Reference No:	2026/62/91498/W
Site Address:	28, Heaton Road, Paddock, Huddersfield, HD1 4HZ
Description:	Erection of two storey side extension
Recommending Officer:	Joshua Merriman

DECISION – Full Conditional Permission

Officer Report – 2026/91498

Plan	Scale 1:100	A 2366/2
------	-------------	----------

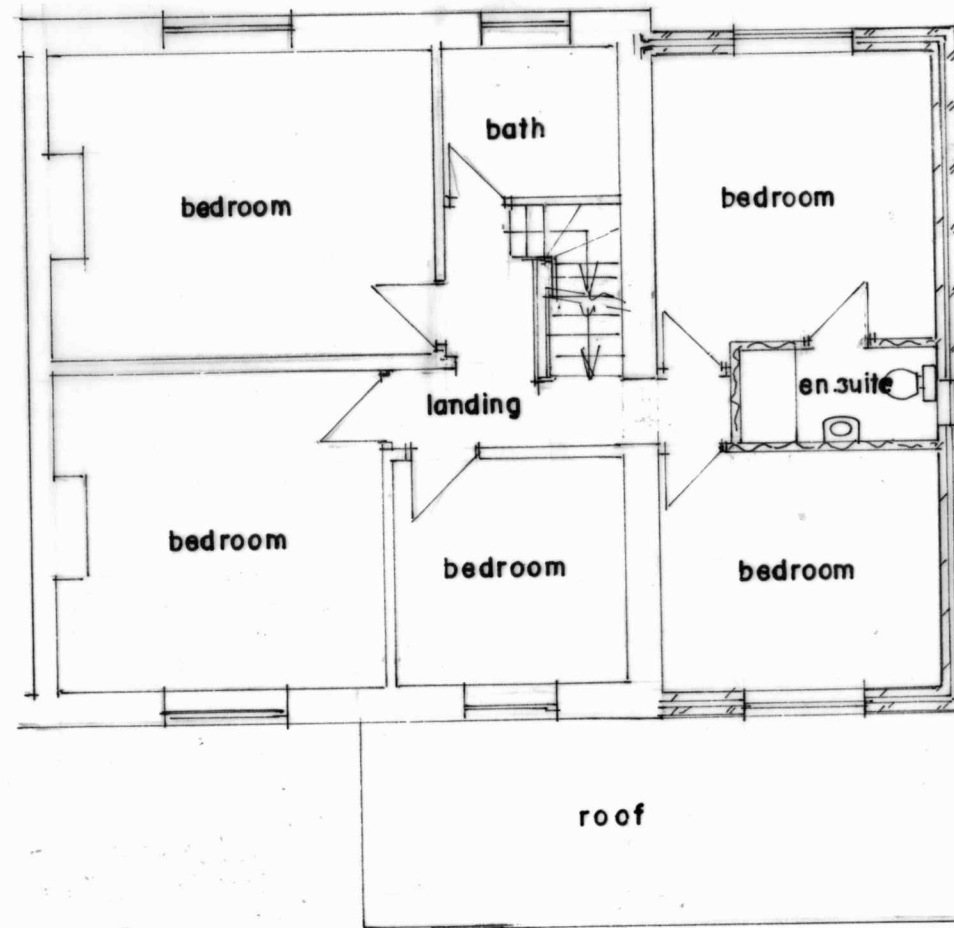
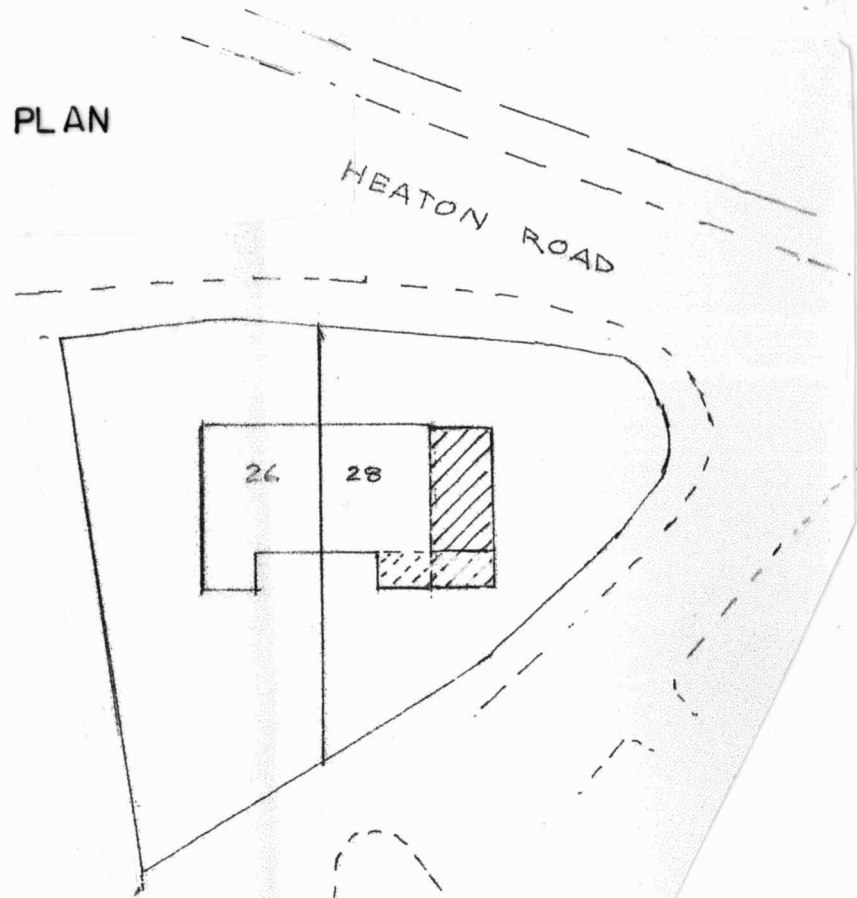
The two-storey side extension does not take up all the space to the side of the property and retains a 1m gap to the side boundary. Given that there is no neighbouring property to this side of the dwelling, it is considered that there would be no adverse impacts on residential amenities as a result.

The proposal will increase the number of bedrooms in the property from three to five, however, as the extension will be entirely within the footprint of the existing dwelling when considering the single storey element has received prior permission under application 2025/9091, the scale of the hard-standing parking area on site will not be impacted, therefore, the current parking provision at the property is acceptable to remain as it would provide 3 parking spaces aligned with the off-street parking provision required. Furthermore, the proposal is set well back from the closest highway and is not considered to have any significant impact upon highway safety.

A 2366/ 3

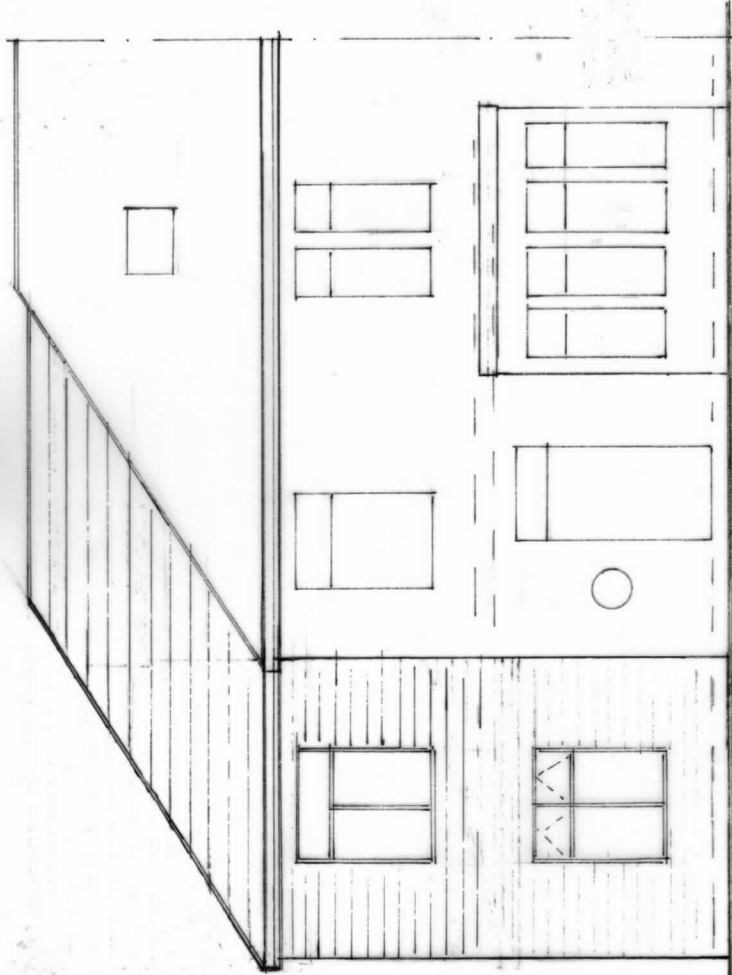
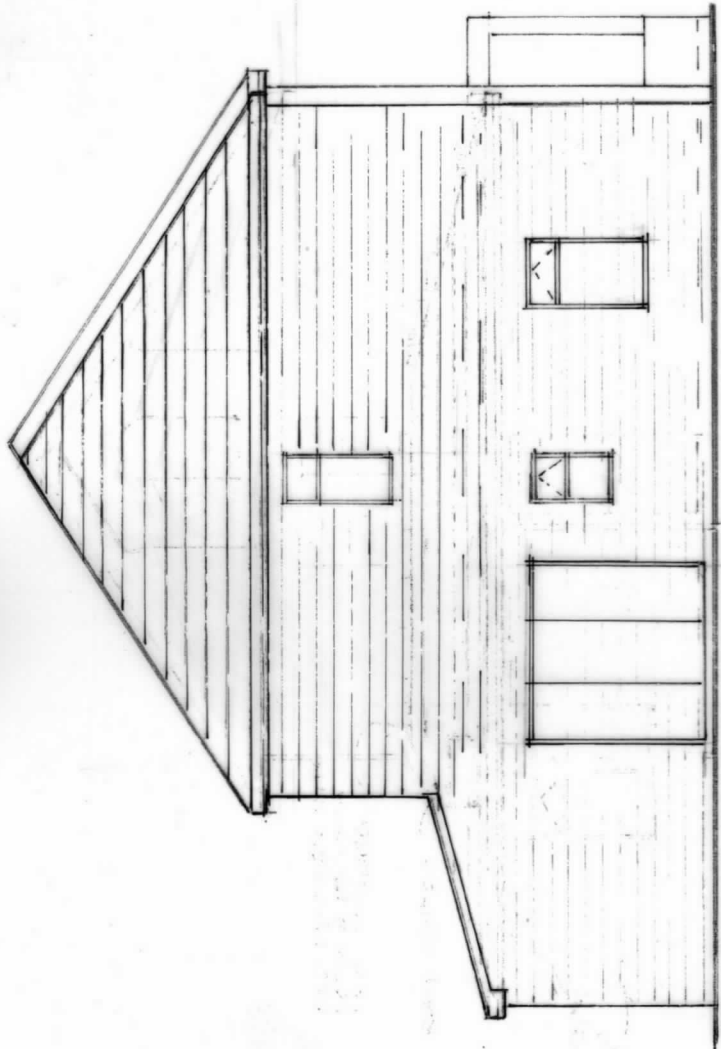
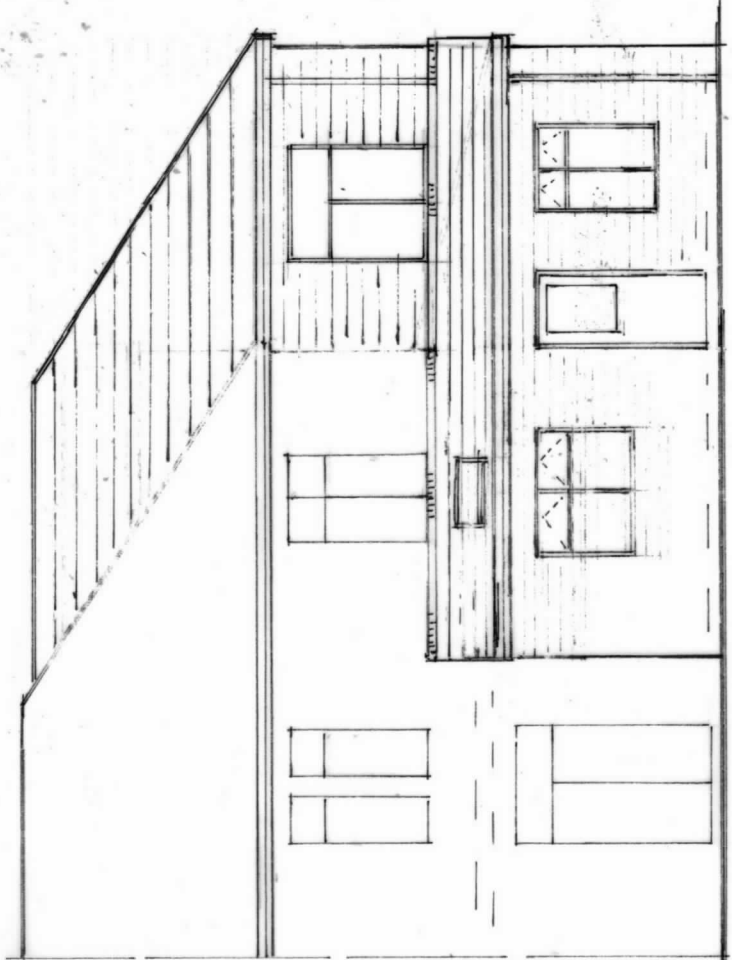
Officers requested the use of a pitched roof to follow the existing roof form, rather than the originally proposed gable roof. Amended plans were submitted detailing this. Due to the nature of the amendments, further publicity was not deemed necessary and no neighbour was prejudiced.

The two-storey side extension, although not set back 500mm from the front elevation of the existing building, is considered to be adequately set back to maintain a visual break. The proposal will also have a roof design which follows that of the existing building following receipt of amended plans, and use sympathetic materials including stonework and roof tiles to match the existing property.
